Submission on Shoalhaven Starches Modification 26

MP06_0228-MOD-26

Kylie Knight

Bomaderry resident, community advocate and member of the Shoalhaven Starches Community Consultative Committee

Figure8 : Elevations of Product Silos

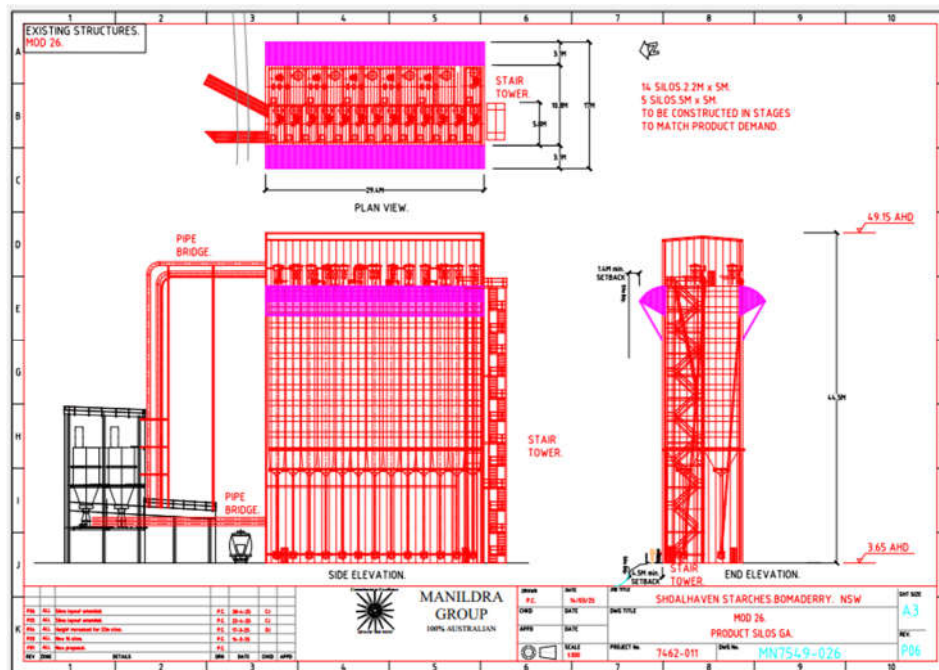
51. The Mod 26 documents are also inconsistent about whether 15 or 19 finished-product silos are proposed. This raises legitimate concerns about quality control and whether all technical assessments are based on the same final project description.
